REF: SSD-78156462

**RE: REQUEST FOR ADDITIONAL INFORMATION – SSD-78156462  
PROPERTY AT: 12-16 Bent Street LINDFIELD**

I refer to the Request for Further Information (RFI) provided by DPHI via Major Projects dated 21<sup>st</sup> October 2025 and recent email correspondence dated 4<sup>th</sup> November 2025 in relation to SSD-78156462 for a Residential Flat Building with infill affordable housing at 12-16 Bent Street, Lindfield (the Site).

Title
Q-COMPLIANCE DIAGRAMS
AFFORDABLE GFA PLAN

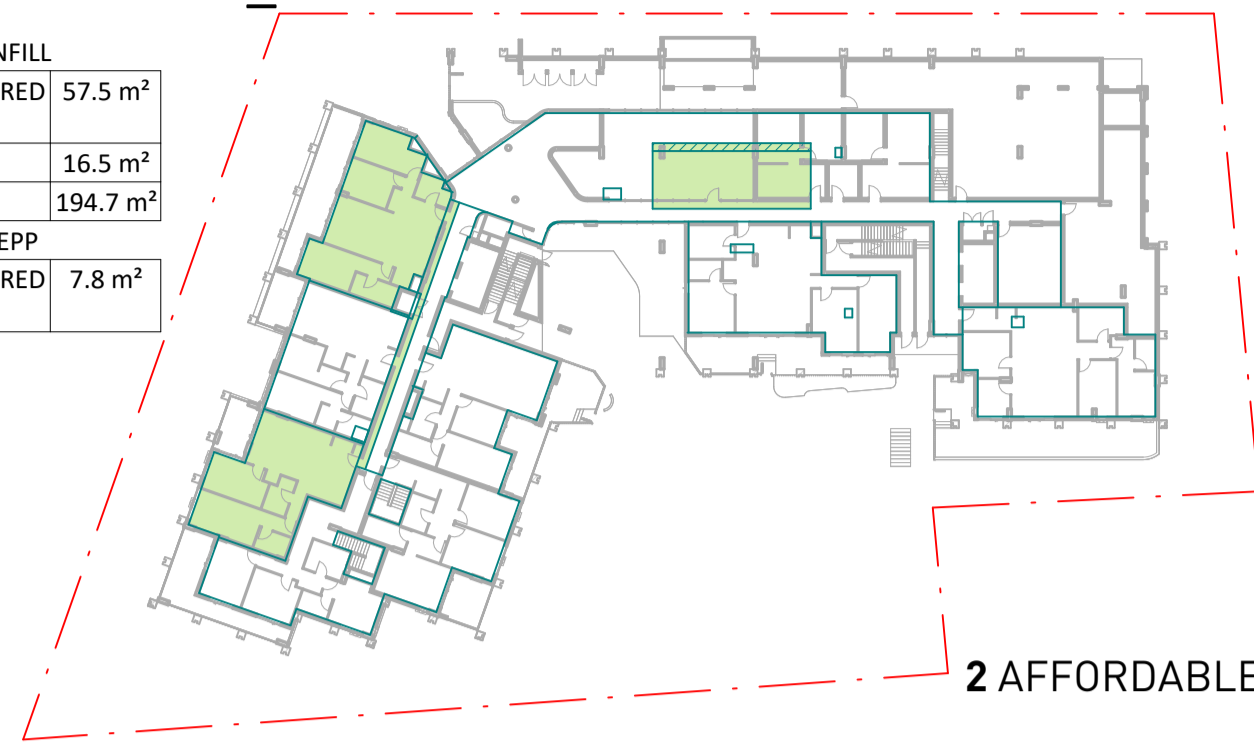
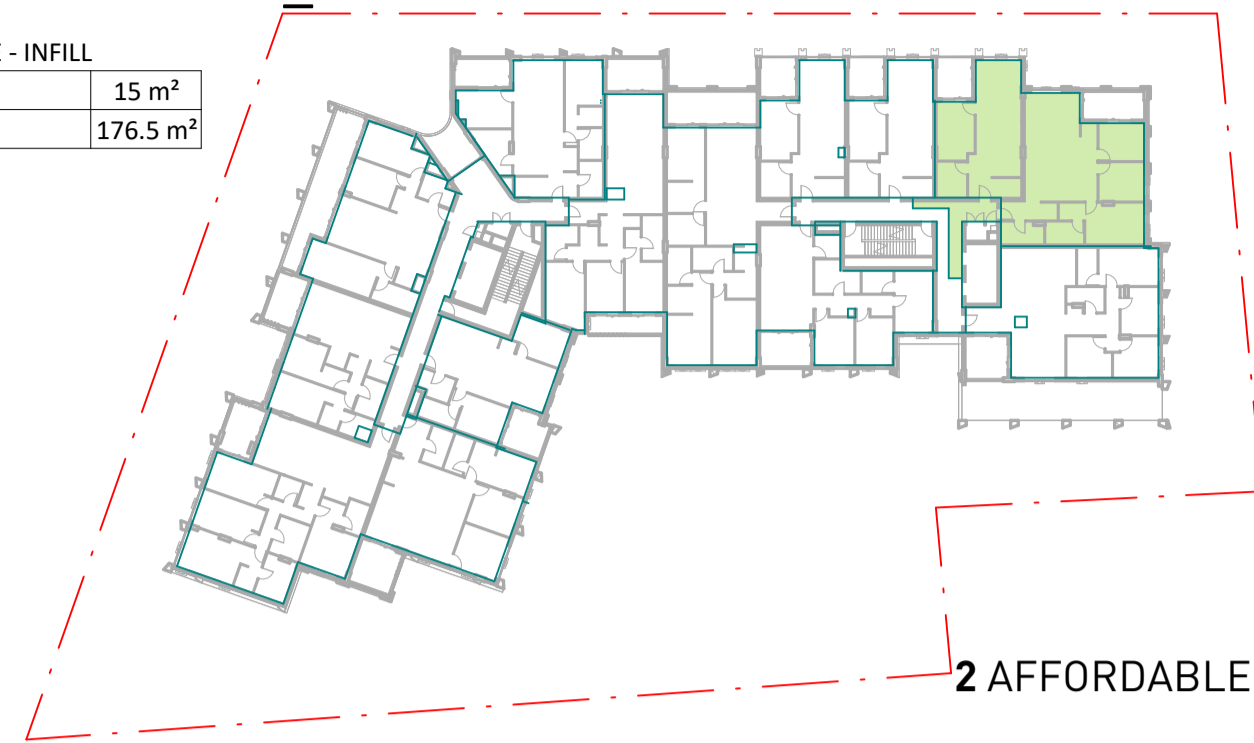
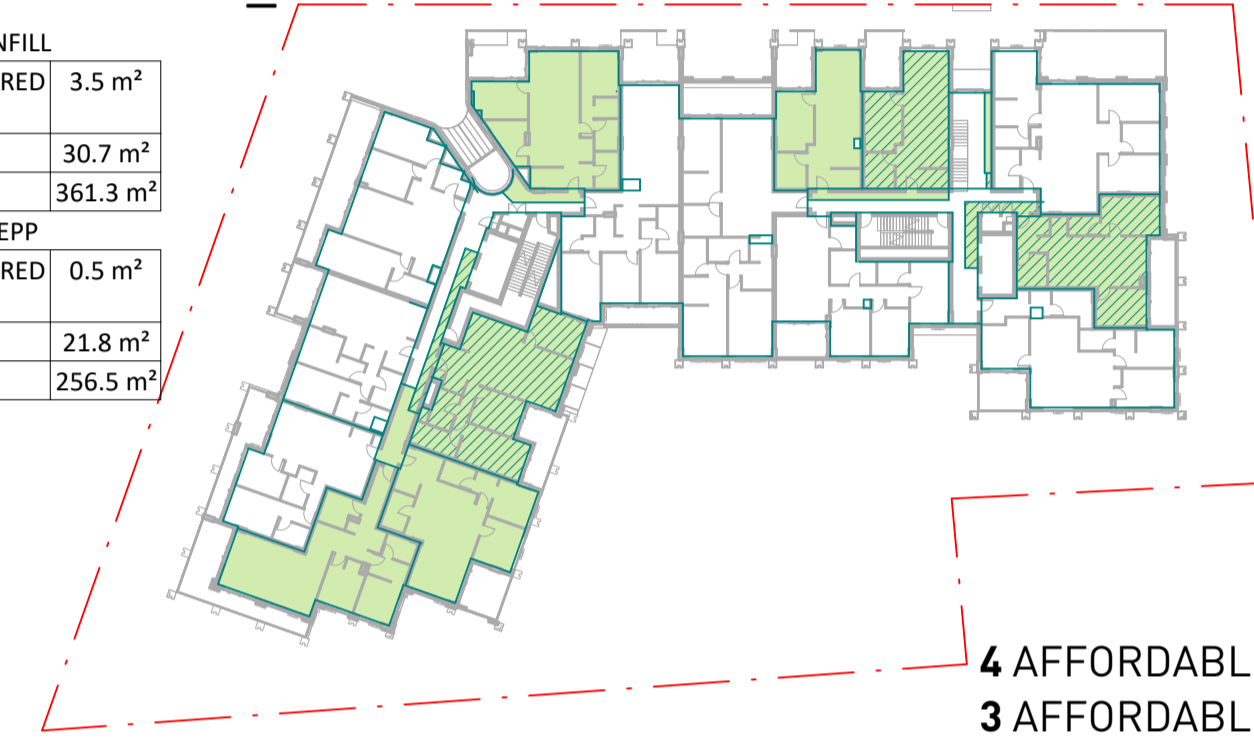
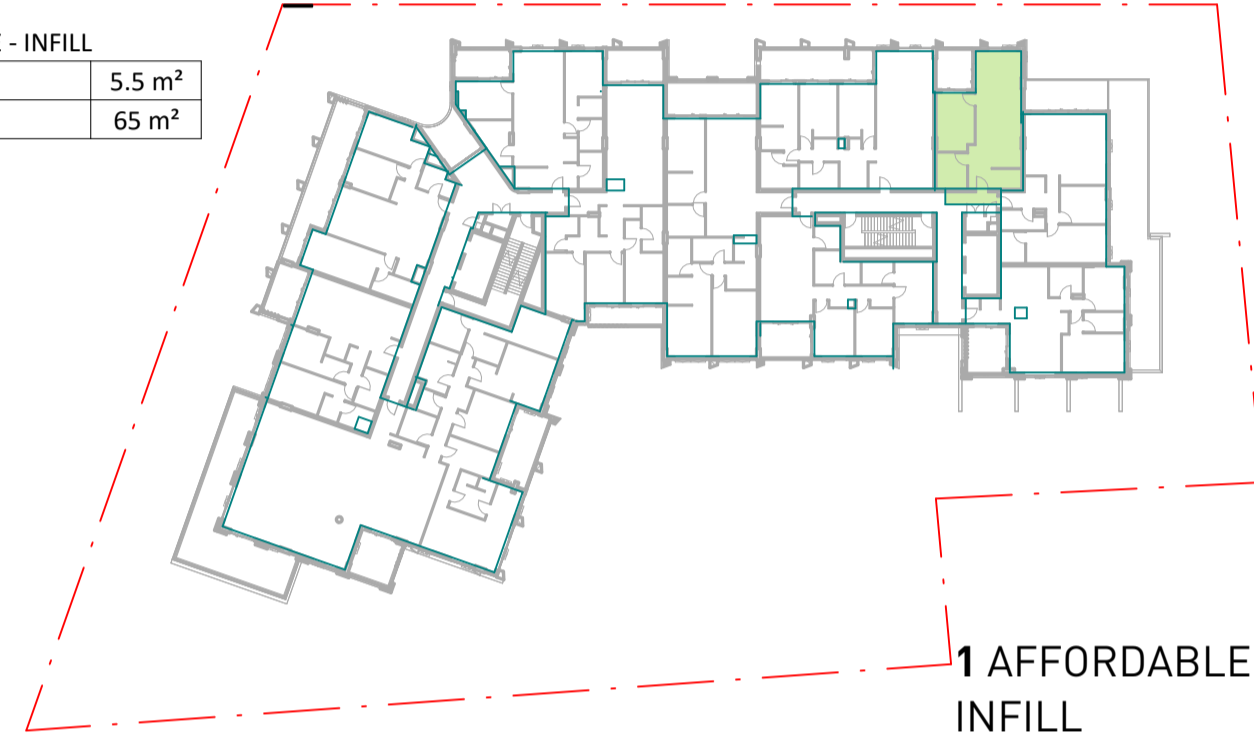
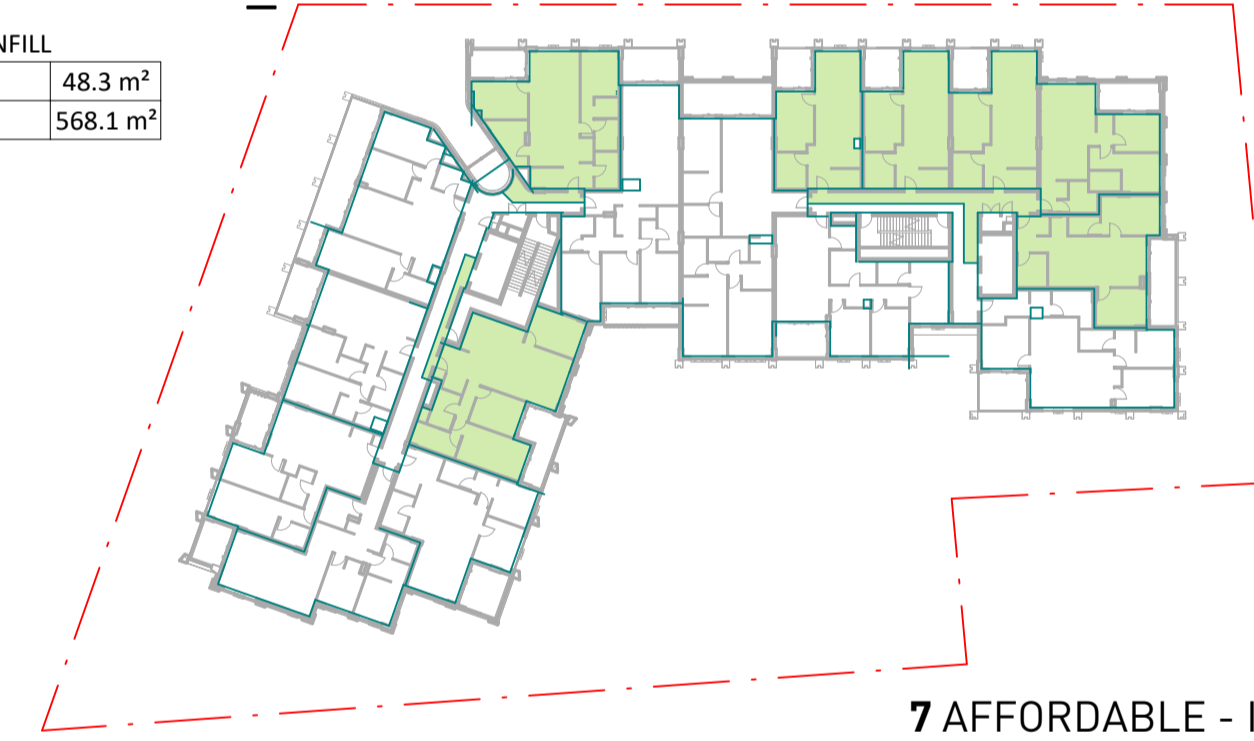
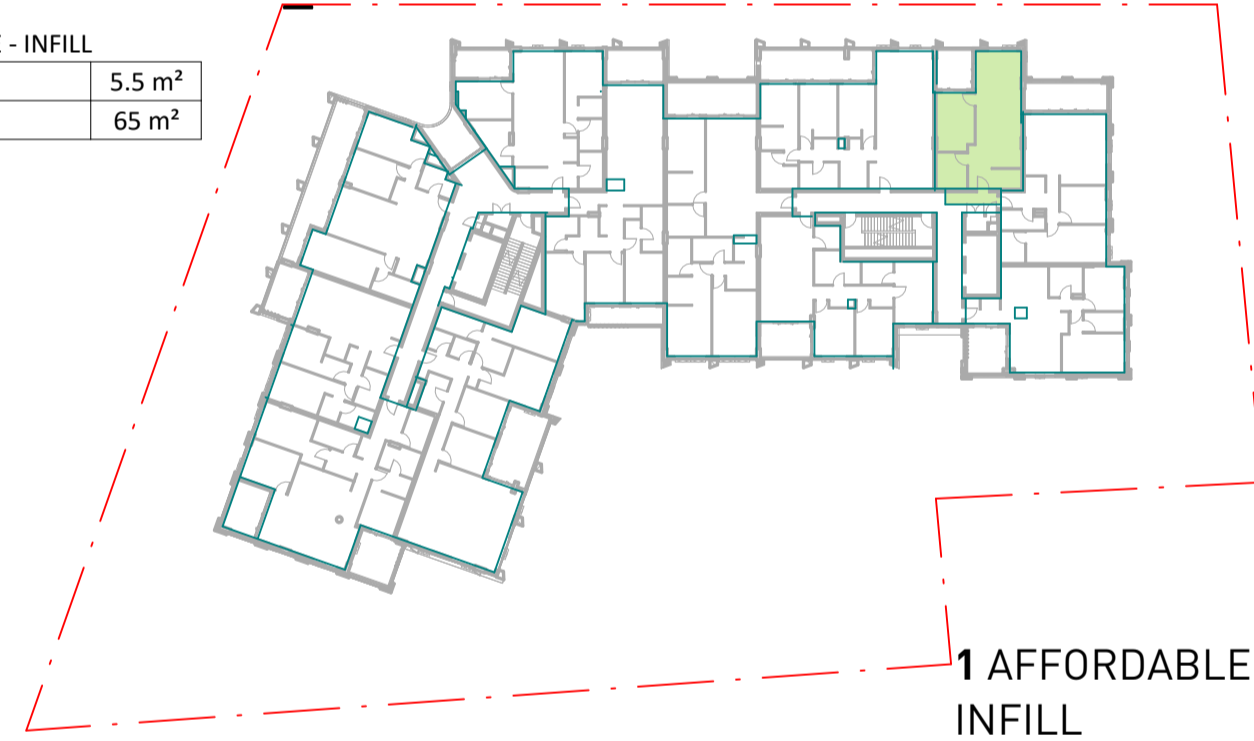
The Department notes that the overall GFA and, in particular, the affordable housing GFA has been incorrectly calculated.

*We note that the proposed FSR is now 3.19:1 which is below the 30% bonus (27.9%). The proposal still seeks for a 30% height bonus under clause 16(3) of the Housing SEPP. To address this discrepancy, you propose to increase the affordable housing provisions to be 17% of the maximum allowable GFA on the site, being 14,053m<sup>2</sup>. The Department agrees to this approach.*

*However, the amended architectural plans identify that 17% of 14053 m<sup>2</sup> (2389 m<sup>2</sup>) has not been allocated as affordable housing. The circulation areas have been deleted from the allowable GFA and then 17% of the residual GFA (total – circulation) has been allocated to affordable housing. This means that the circulation area has been entirely deleted from the GFA calculations.*

*The definition of GFA or provision of bonuses do not specify deletion of circulation areas.*

*Consequently, 2389 m<sup>2</sup> is required to be dedicated as affordable housing and then divided as 15% infill and 2% in perpetuity. You are allowed to include circulation areas in the 17% affordable GFA. The circulation areas can be apportioned between market and affordable GFA, in case the two types are proposed on a single floor. If an entire floor is dedicated to affordable housing, then it can include all the circulation areas in the GFA.*

*Please submit revised calculations and amend the calculations in the Architectural plans to address this GFA inconsistency.*

- The revised architectural plans (**Appendix 3**) reintegrate circulation areas into the GFA calculations as directed, with the 2,389 m<sup>2</sup> affordable housing allocation (17% of the maximum allowable GFA of 14,053 m<sup>2</sup>) apportioned as 15% infill and 2% in perpetuity in accordance with clause 16(4) of the Housing SEPP.
- Circulation areas are now appropriately attributed to the relevant GFA categories on a floor-by-floor basis, with apportionment between market and affordable housing reflected where floors are mixed-use, and entire floors dedicated to affordable housing including all associated circulation areas.
- The amended statutory compliance table (**Appendix 4**) provides detailed GFA calculations with cross-references to the revised architectural plans, demonstrating compliance with the Housing SEPP bonus framework and FSR/height provisions.
